Our ref: NE/2011/113319/01-L01
Your ref: S6/2011/1994/MA
Date: 8 November 2011

Regeneration of Salisbury Square, Old Hatfield, Herts.

Drawing file: PROPOSED SITE PLAN - GROUND LEVEL - VALIDATED 28-0.PDF

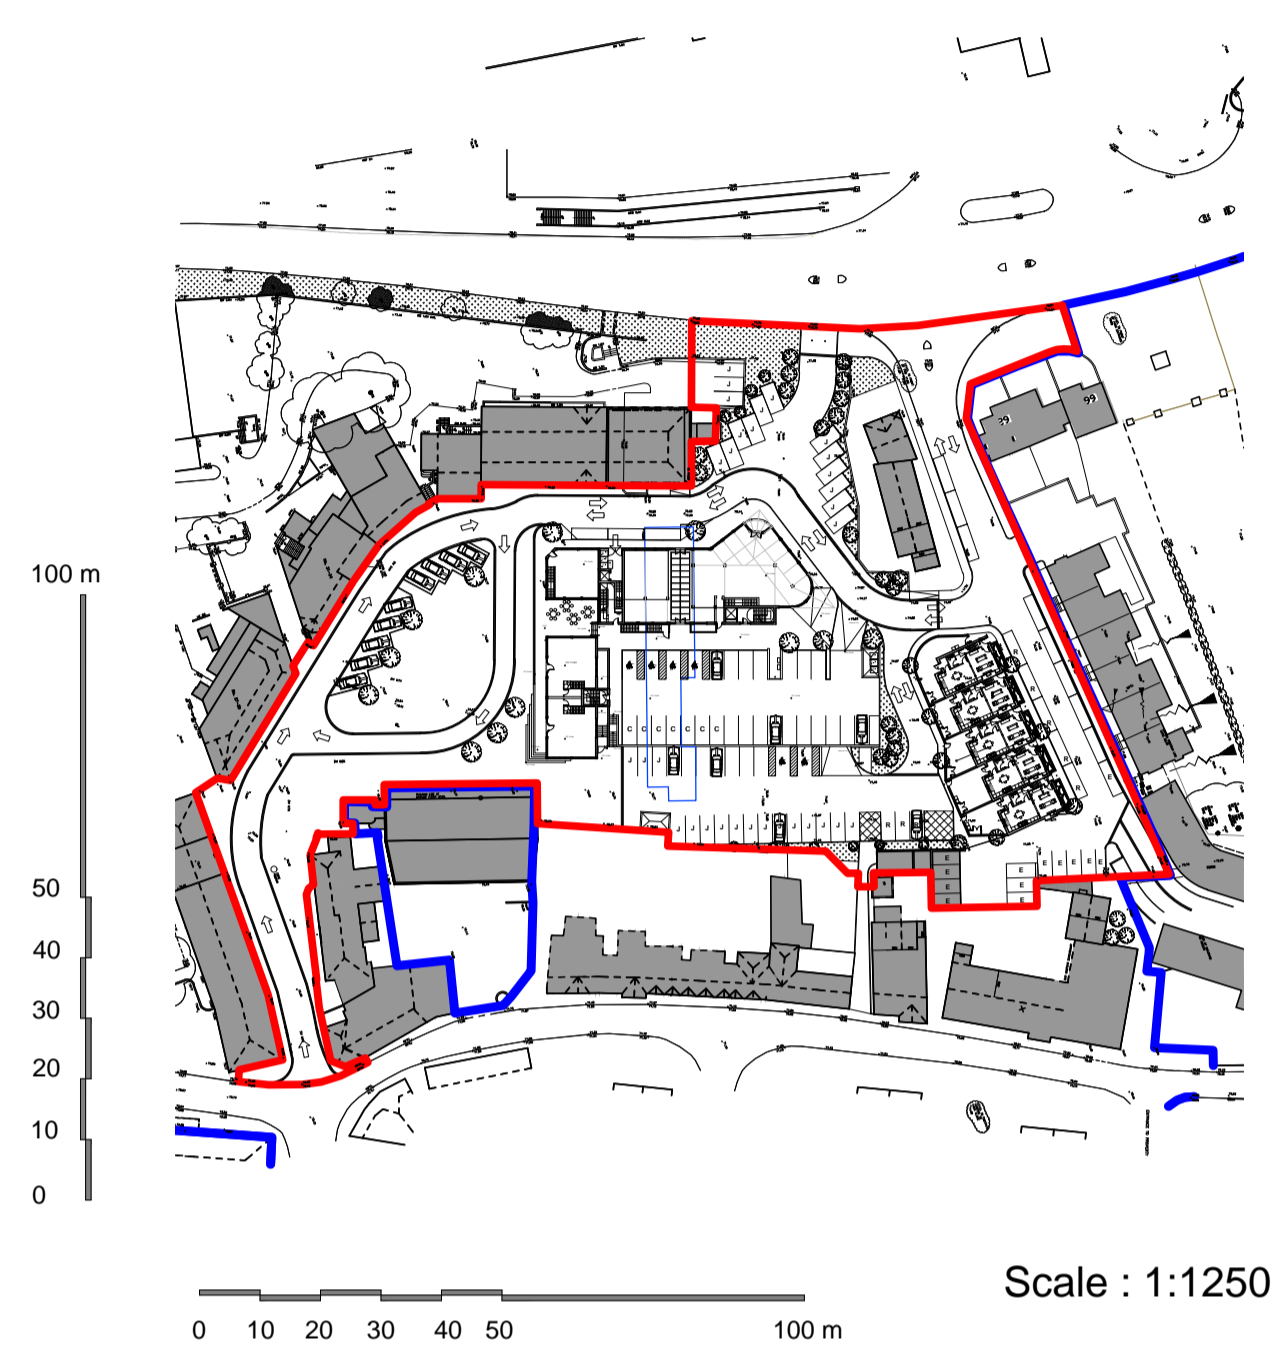
The FRA states that there is no space for ponds to be provided. This is confusing because the development proposals show a relatively large open space on Salisbury Square to the rear of York House. This would be an ideal location for a pond. It would provide surface water attenuation, improve water quality and enhance biodiversity of the area. It could also act as a focal point of the square away from the shops and car parking areas.

The FRA also states that permeable paving is not appropriate at this site. This may be the case but the roads and car parking areas could be permeable with tanks underneath. This would significantly improve the quality of the water being discharged from the site in comparison to what will be discharged from the currently proposed drainage system.

The predicted life time of a residential development is 100 years so this may be the only opportunity to enhance biodiversity and water quality in the area for a long time. We would strongly urge you to take our comments on board and ask the applicant to amend the proposed drainage scheme so it is as sustainable as possible.
